RE: 2025/92088 Discharge of conditions

Further to the discharge application in connection with the above, I would like to advise that Condition 9 (retaining walls) can not be discharged pending the submission of a satisfactory “Construction Compliance Certificate” together with amended “As Built” drawings to conclude the technical approval of the design of the relevant structures.

**AS BUILT DRAWING**

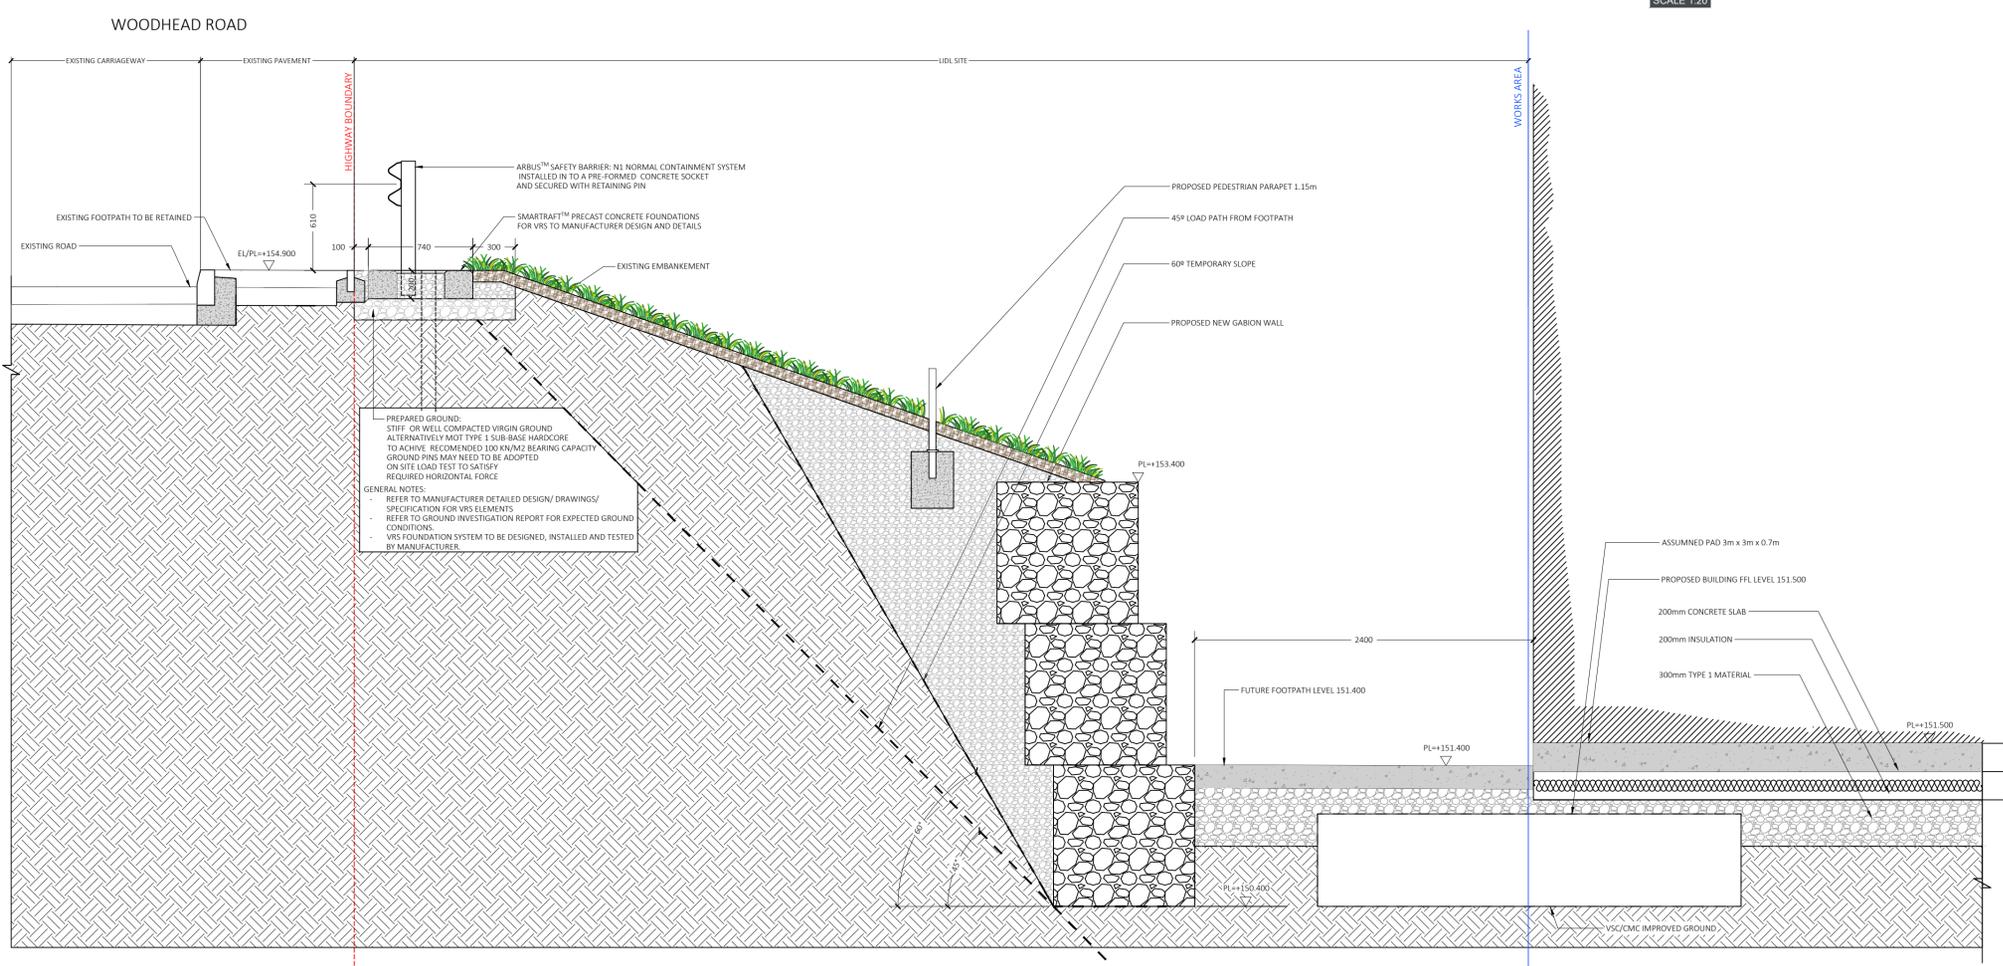
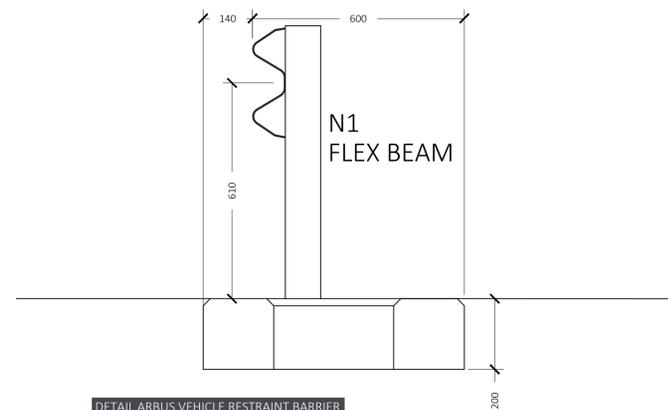
Please note that the submitted “As Built” drawings include some anomalies which has been brought to their attention but have not been actioned.
